**KIRKLEES METROPOLITAN COUNCIL
INVESTMENT & REGENERATION SERVICE**

**DELEGATED DECISION TO DETERMINE APPLICATIONS FOR
CONSENT, AGREEMENT OR APPROVAL REQUIRED BY CONDITION**

Reference No: 2019/44/91067/W

Site Address: Broomfield House, Firth Street, Huddersfield, HD1 3DA

Proposed Landscape Site Plan

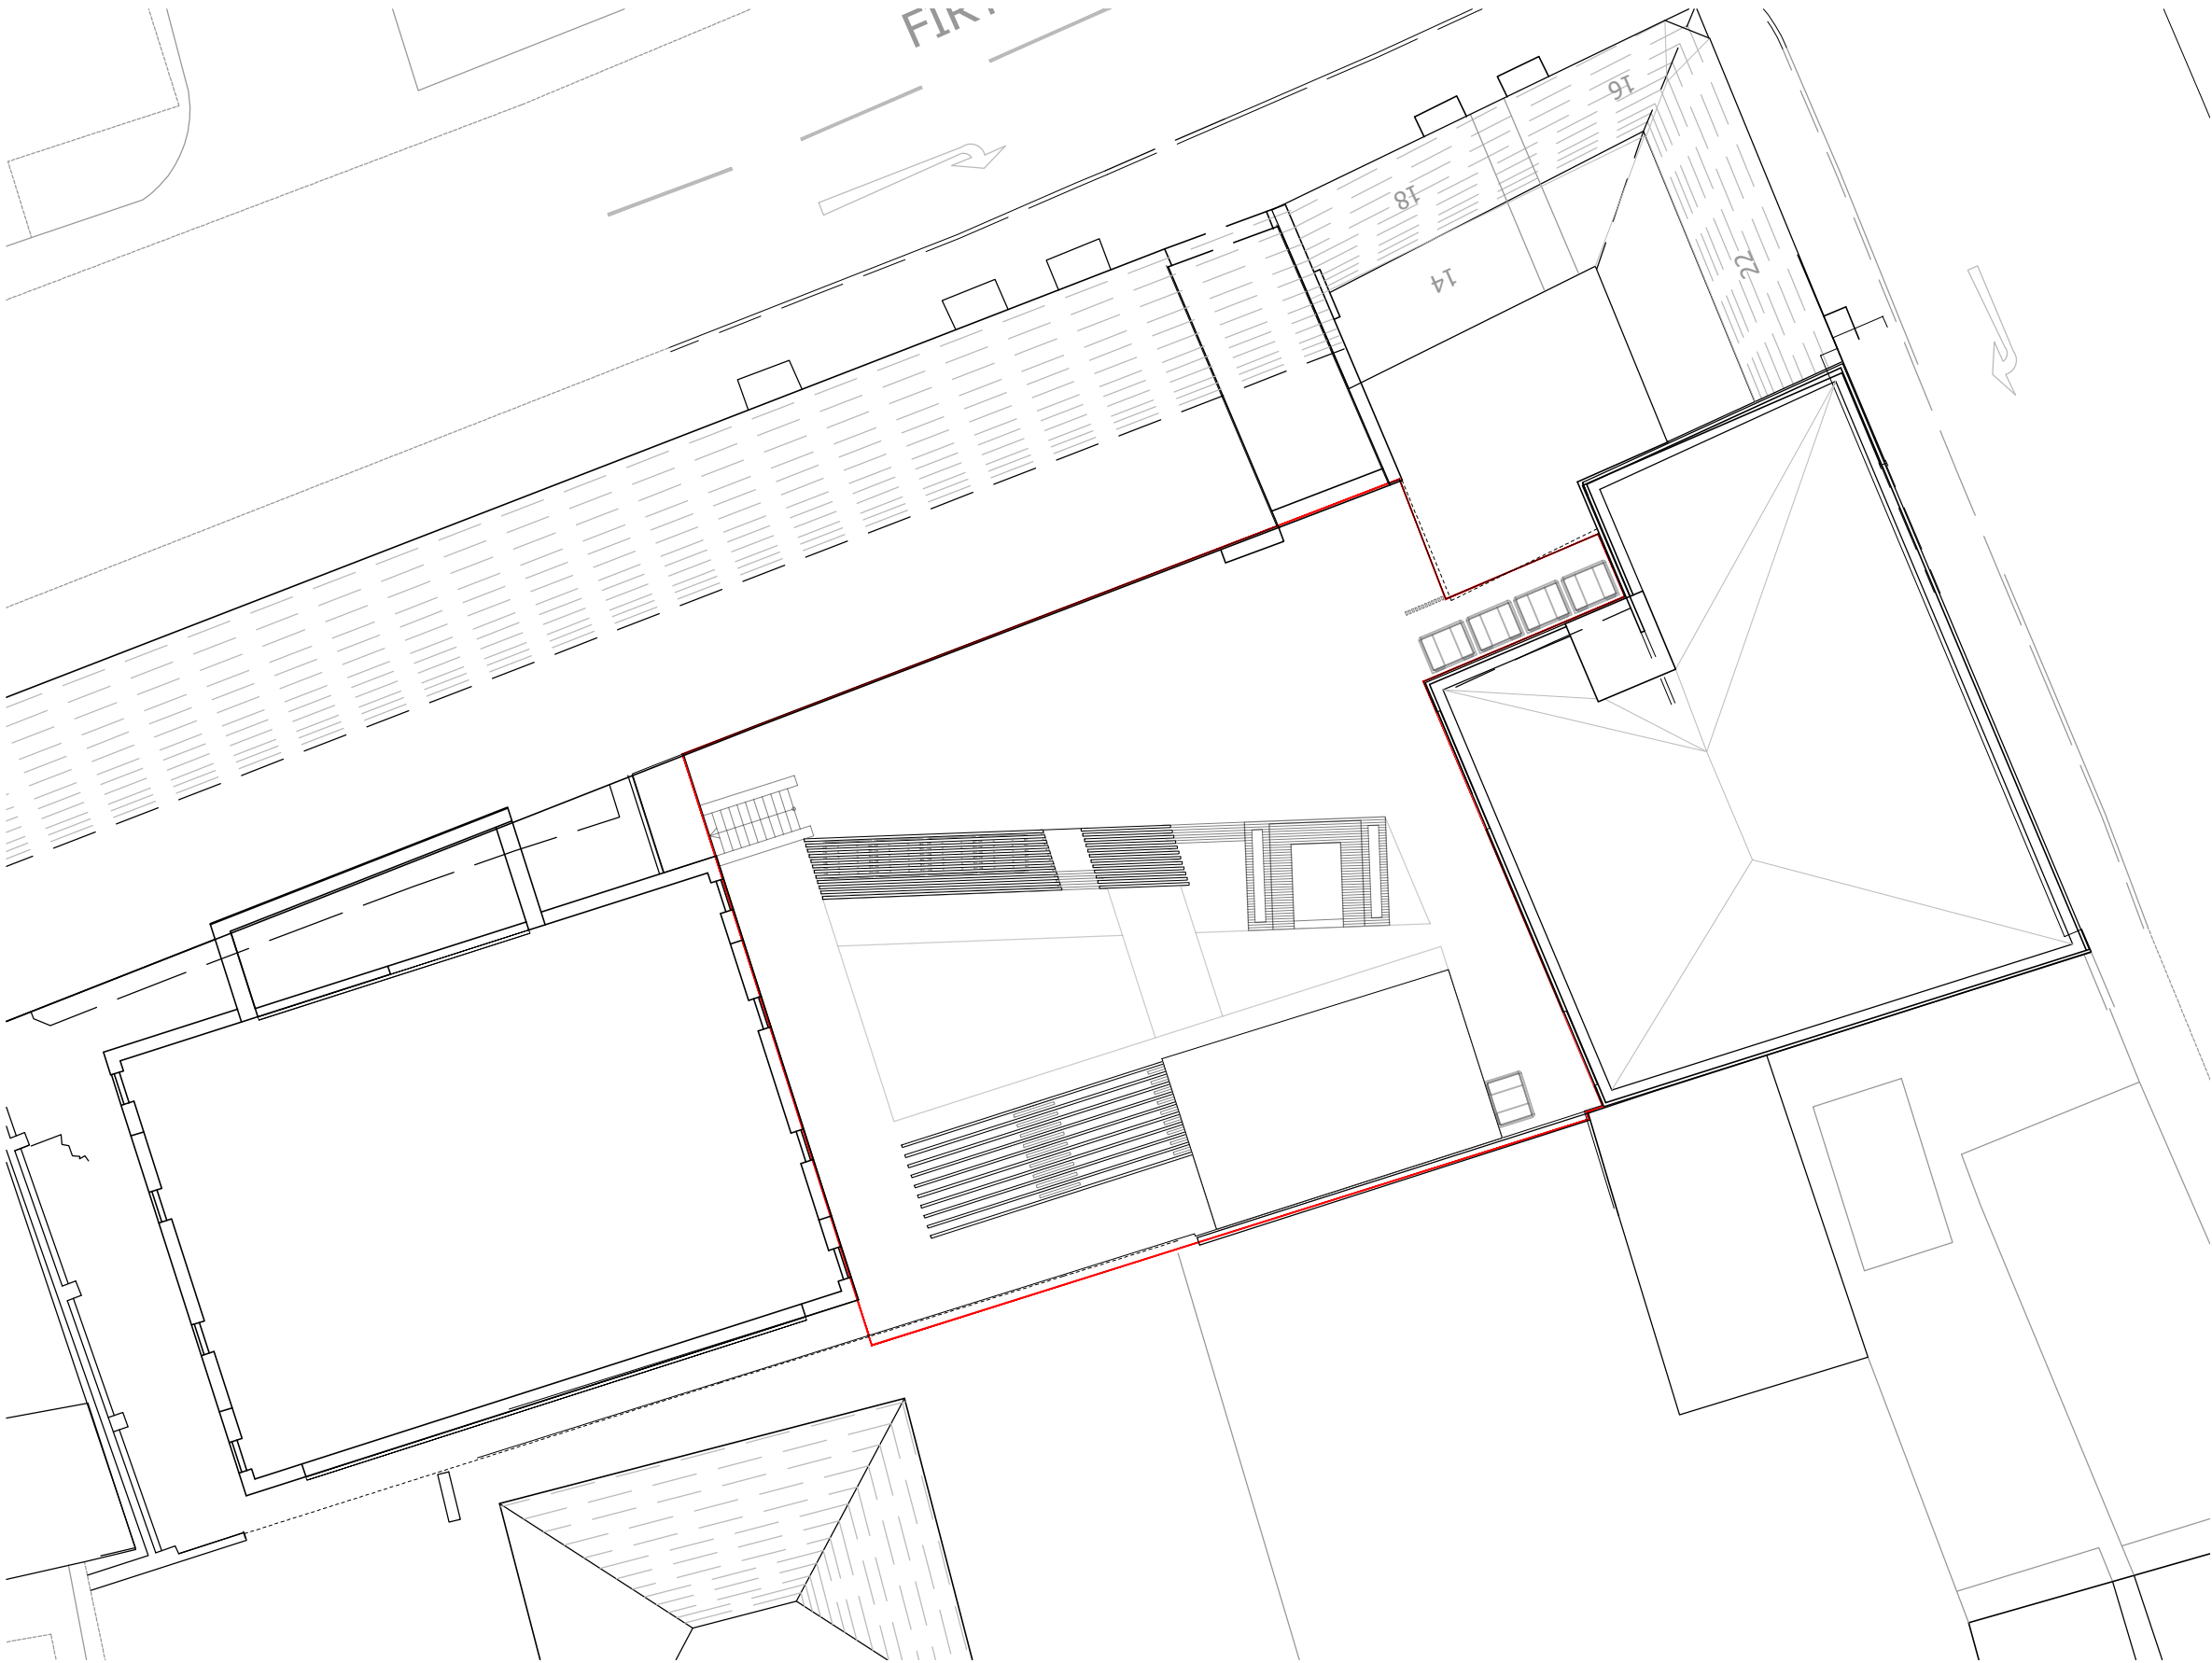
For the current application, the applicant provided drawings of the courtyard (between blocks A and B), showing bin stores, a sunken seating area, a gym and a pergola. Tarmac was the only surface material annotated. The layout of the courtyard proposed was quite different to that previously shown in the Design Factors document and drawing 100.081.02 rev B, and included no soft landscaping.

Officers advised the applicant that, as these proposals deviated significantly from the Design Factors document and drawing 100.081.02 rev B, they could not be considered compliant with condition 2, and could not be approved. There was, however, some scope for varying the landscaping design, as condition 2 includes the words "shall follow the principles", rather than "shall strictly accord with".
